From: Amanda Scholes on behalf of Planning.Responses
Sent: 21 October 2020 11:04
To: Planning Scanning
Subject: FW: Re; M/71/20/H 18 Sea Way Elmer Sands PO22 6JY

DRAWING TITLE
**PROPOSED DETACHED GARAGE
FLOOR PLAN AND ELEVATIONS**

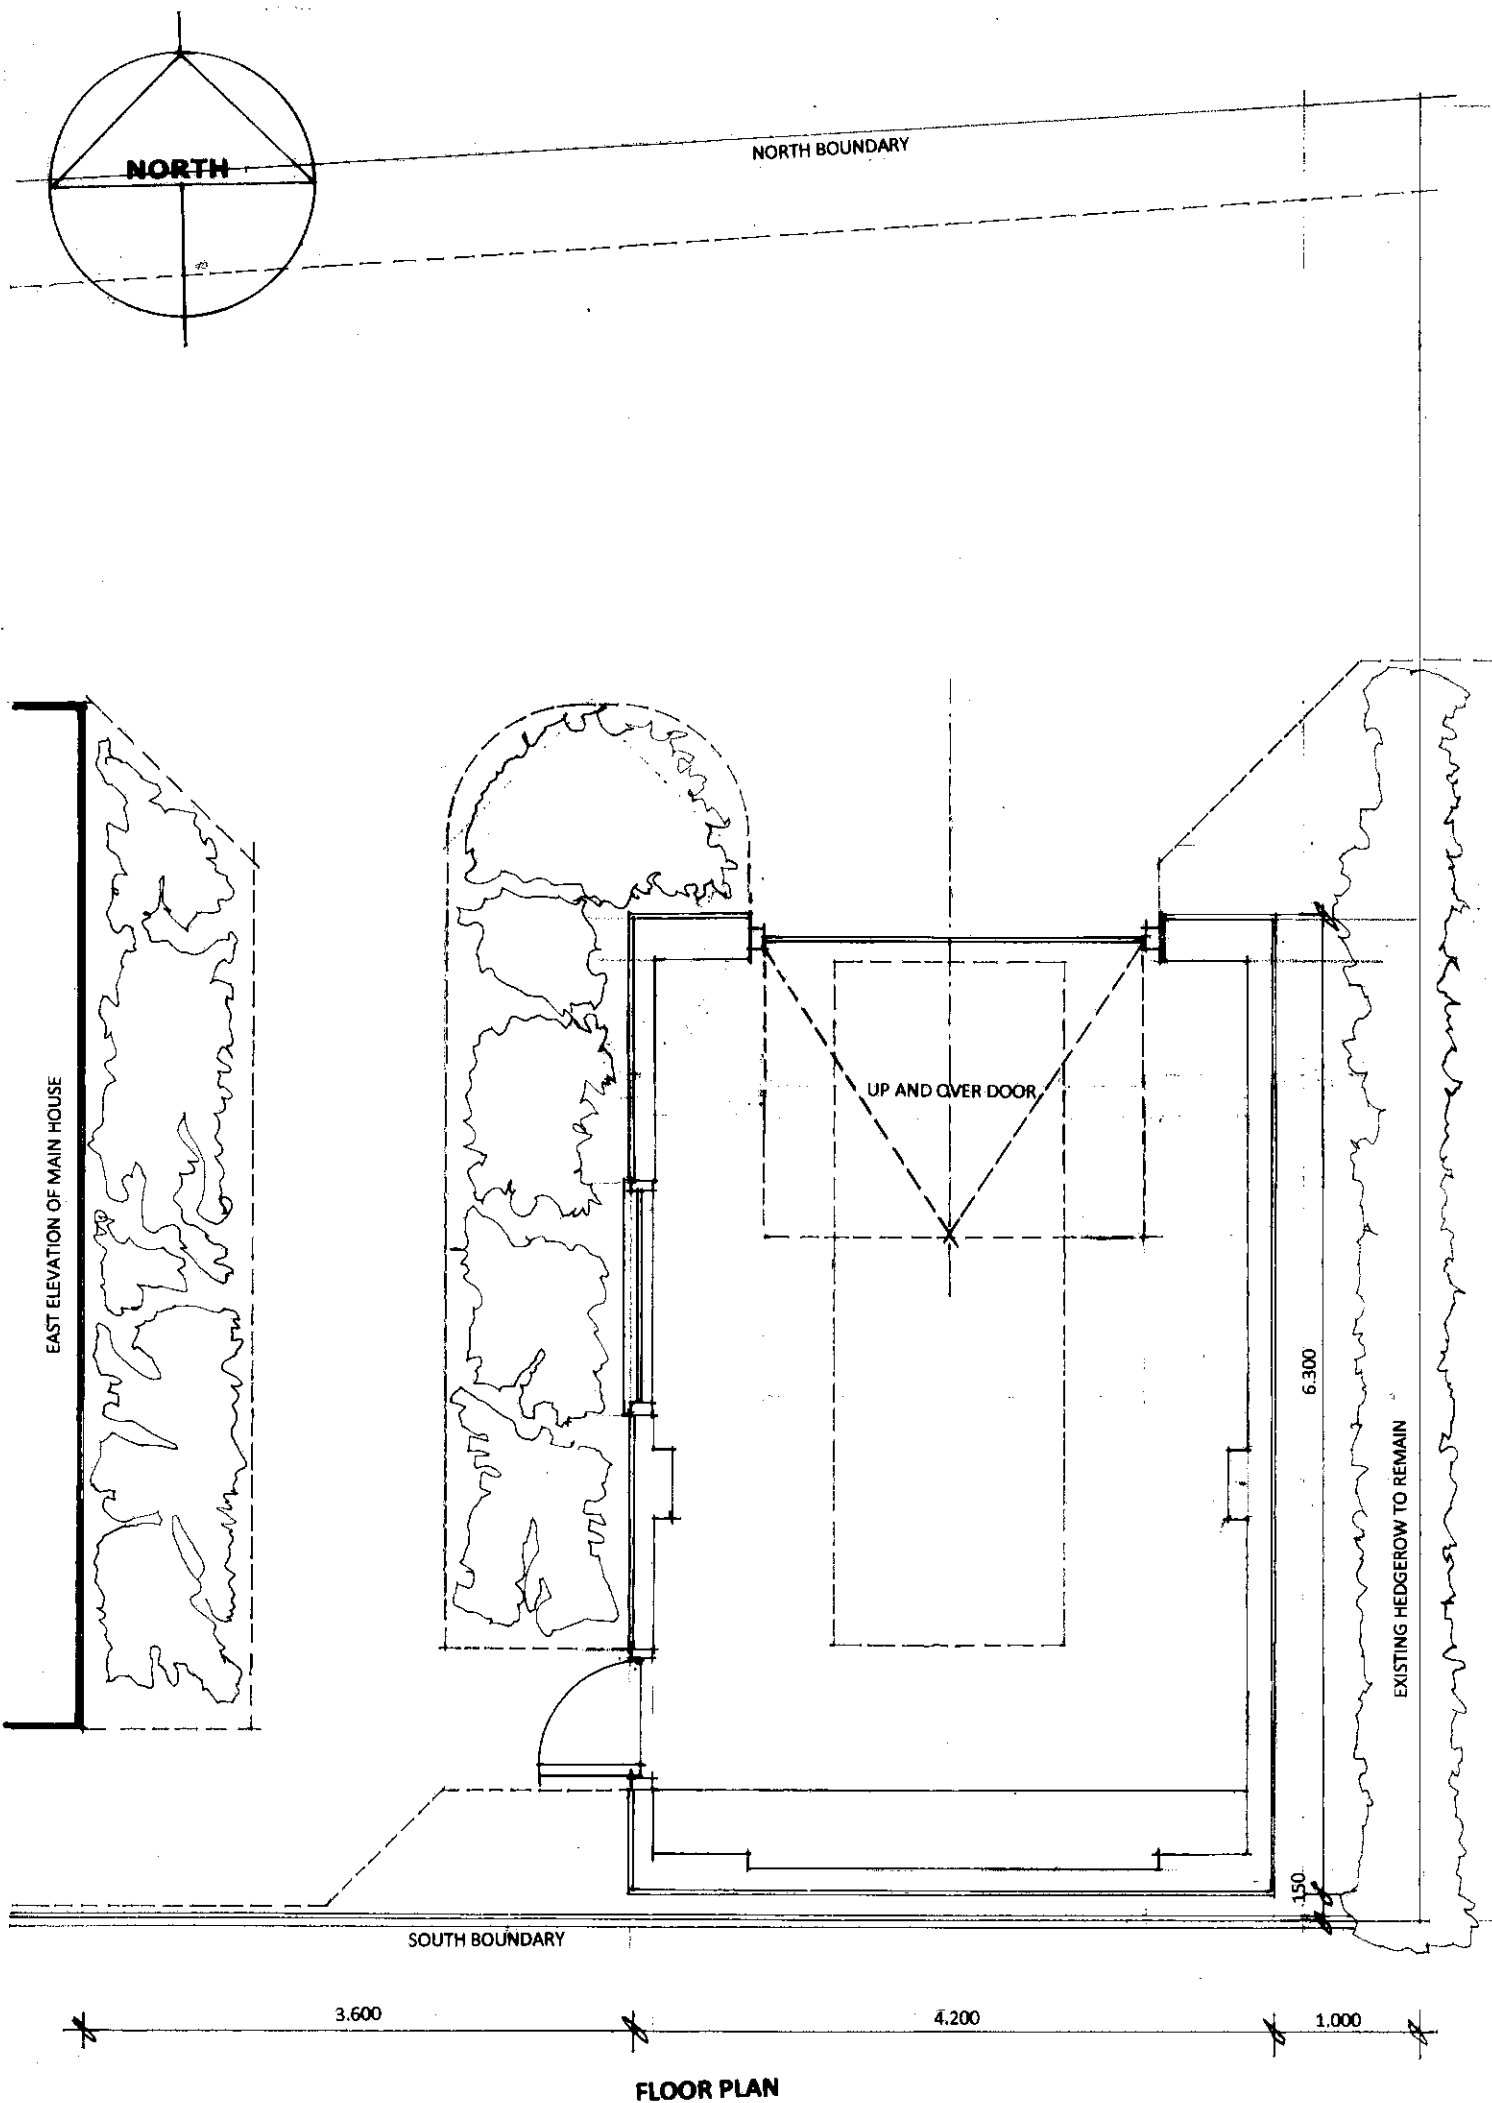
I will be one that wishes to raise an objection – to the garage only, because of its location. So far in front of the natural building line of the adjacent properties its design is simply out of keeping, its close proximity to 16, spoiling the view from the front conservatory, obtrusive pitched roof which no doubt will cause overshadowing problems, and surface water concerns. I have lived here 38 years and on many occasions each year have seen water laying on both 18 and 16. They are the 2 lowest level plots in the vicinity. I have gone to the lengths of reducing the ground to the front of 16, putting in terram and stone to help with the problem.

I have even put them in the verge adjacent to the drive entrance, as until I did it was semi permanently under water during the winter. Removing such a significant area of natural ground drainage is of extreme concern giving consideration to the water table being only circa 900mm from ground level
